Mark Lintermans
[REDACTED]
Bungendore, NSW 2621
16 October 2021

Director - Social and Infrastructure Assessments
Planning and Assessment
Department of Planning, Industry and Environment
Locked Bag 5022
Parramatta NSW 2124

**NEW HIGH SCHOOL IN BUNGENDORE
APPLICATION NO. SSD-14394209**

PROPOSED SITE PLAN

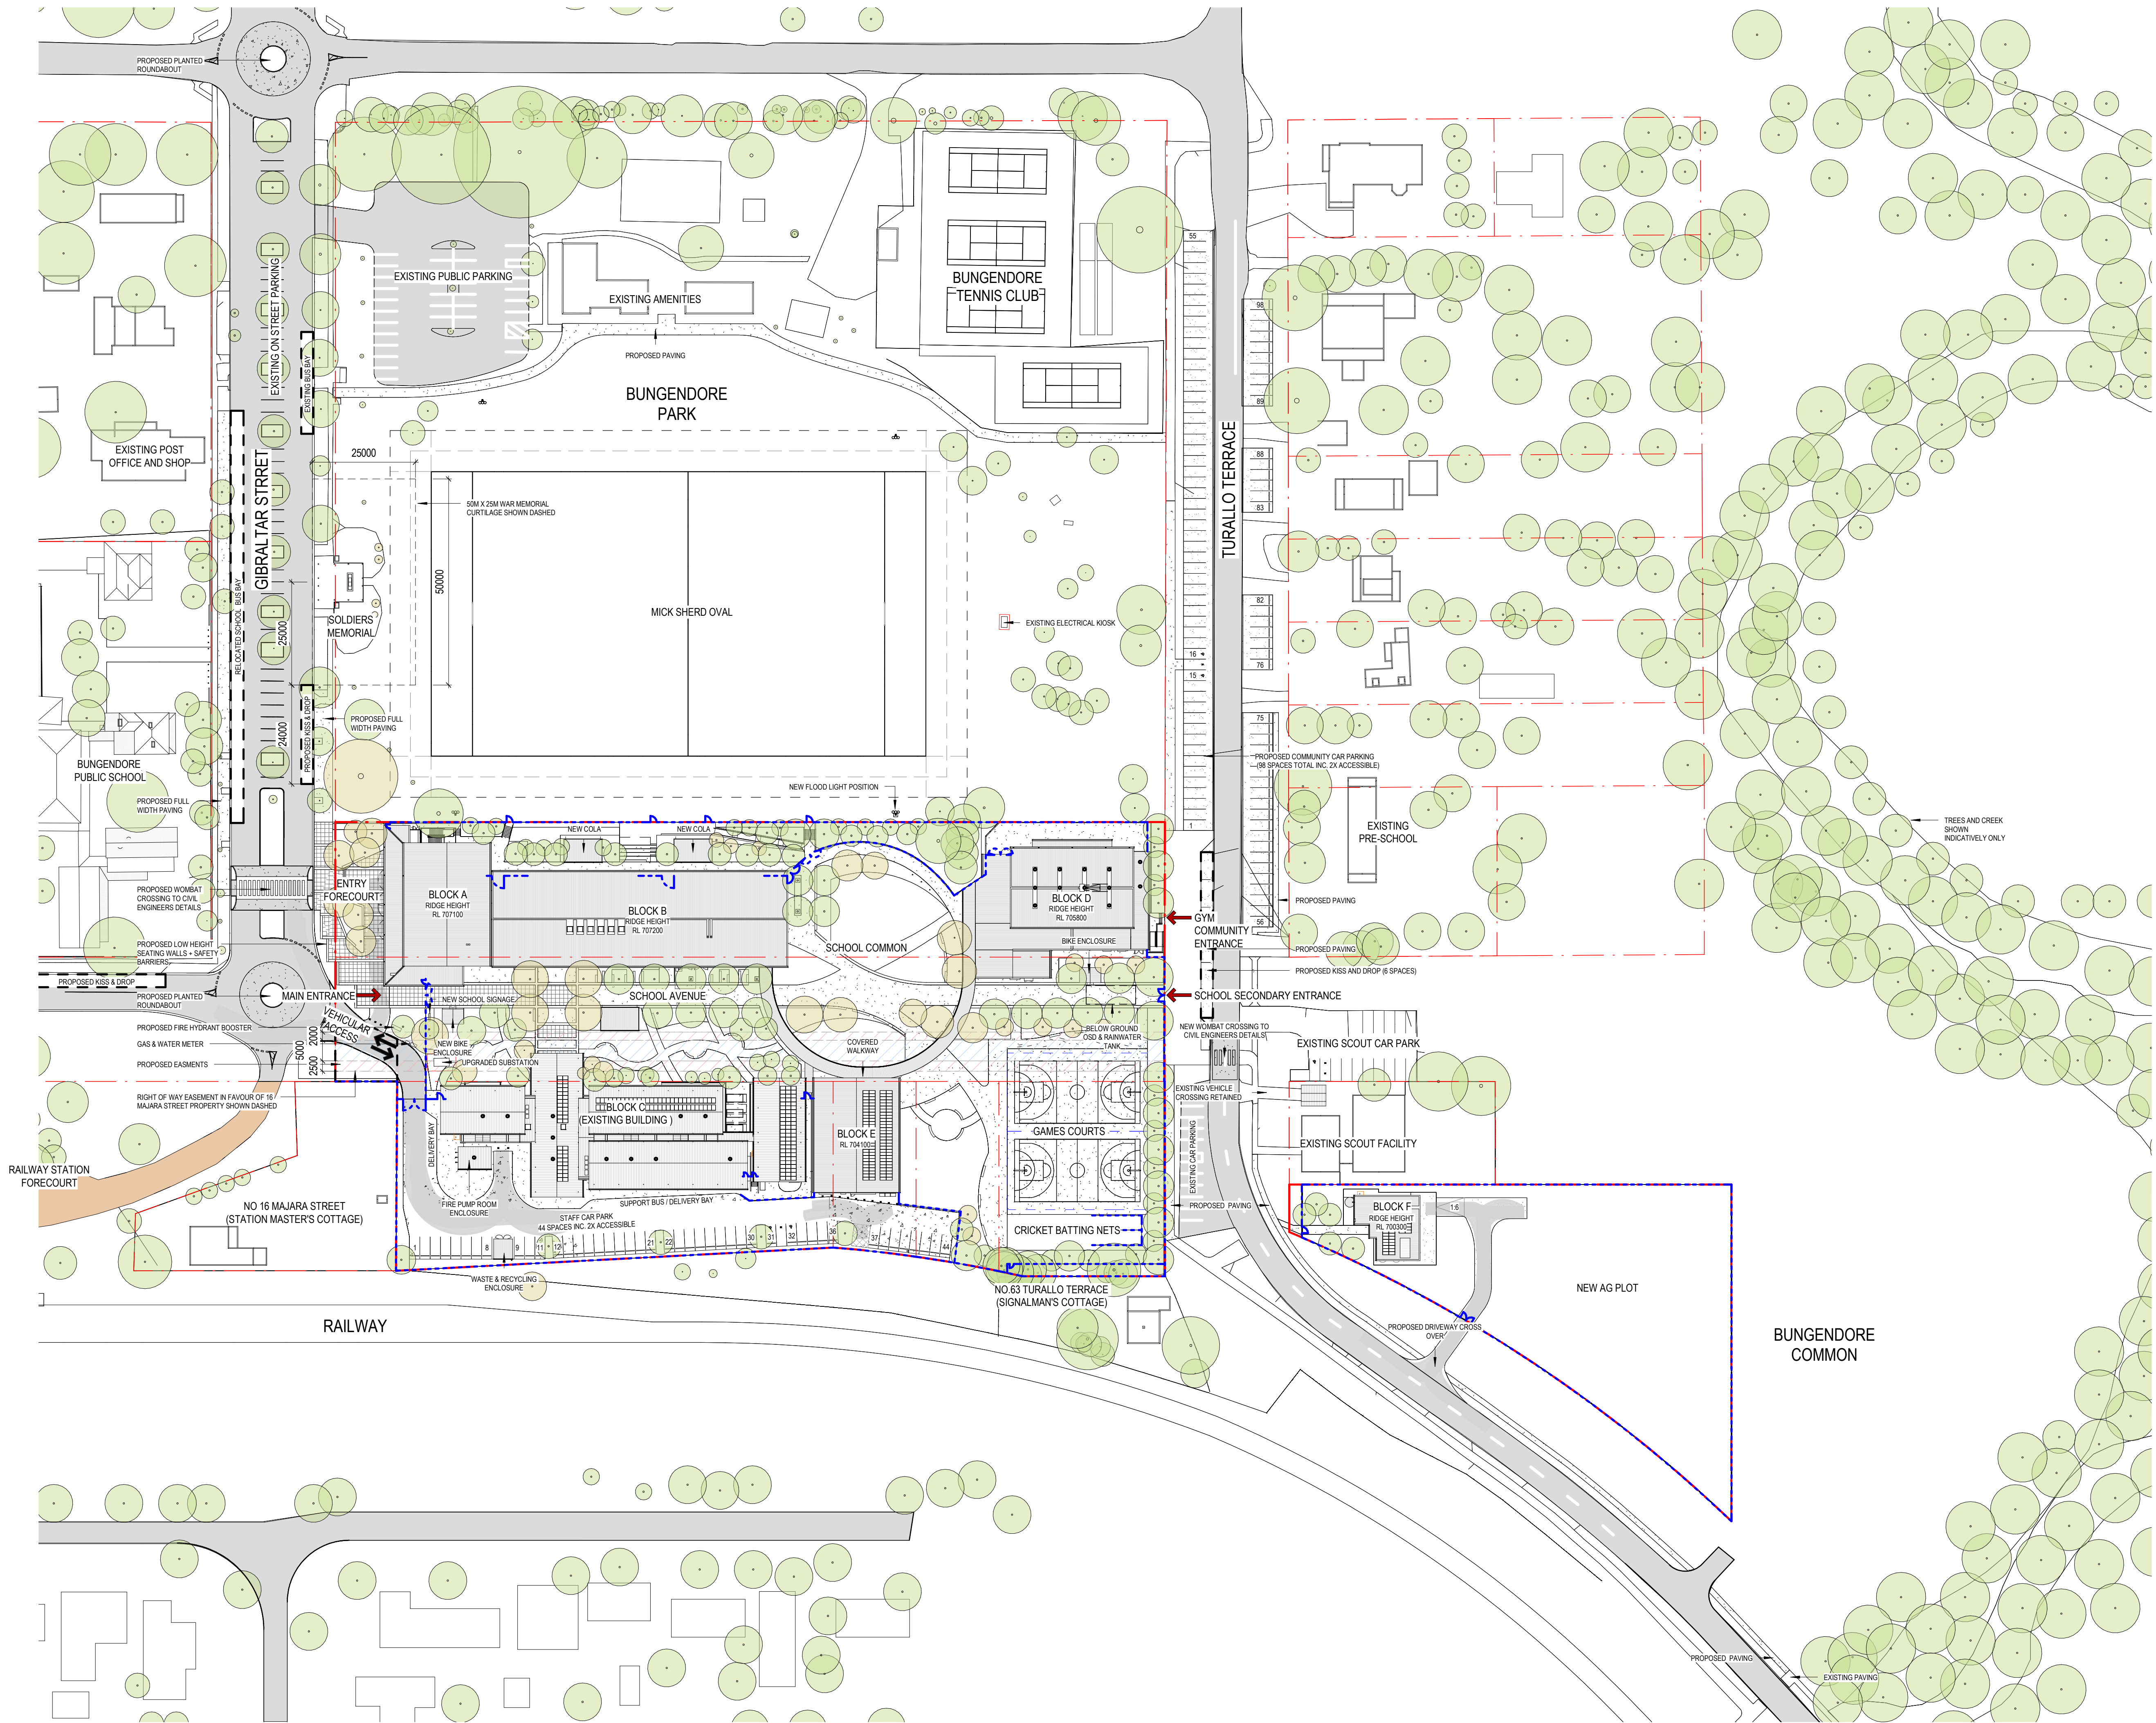
As the resident to the north that is closest to the hall/gym and the outdoor sports courts, I do not consider it "reasonable" at all. The location of the Hall and sports courts directly opposite residences on Turallo Terrace is a very poor, and unacceptable decision. Both the Hall and sports courts are mooted for community use with the Hall to potentially operate until 10 pm on any day of the week. Both the Hall and sports courts should be located either on the current majara St or Gibraltar St sides of the proposed site which are not residential.

Is there going to be lighting on the outdoor sports courts (proposed and in the future with the DA mentioning possible shared facility use with Council?. I strongly object to any proposal that is going to inflect future floodlighting on immediately adjacent residential properties. The DA needs to specifically rule out floodlighting of the sports courts.

The DA proposes “a 2.1m high chain wire fence surrounding Ag Plot”. The Agriculture Plot is being stolen from the ‘Common’ and a 2.1 m chain wire fence is visually intrusive and aesthetically totally incompatible with the remainder of the ‘Common’ . What is the need for a 2.1 m fence? It is certainly not ‘agricultural’ in nature (I would suggest more custodial than agricultural). Maybe the Department of Education could amend the plan to include guard towers at each corner to make doubly sure that no pesky agricultural nuisances (dogs, rabbits, Bungendore residents?) gain access to the plot! Seriously, what is wrong with an agricultural fence (ie 1.2 m high with standard netting).
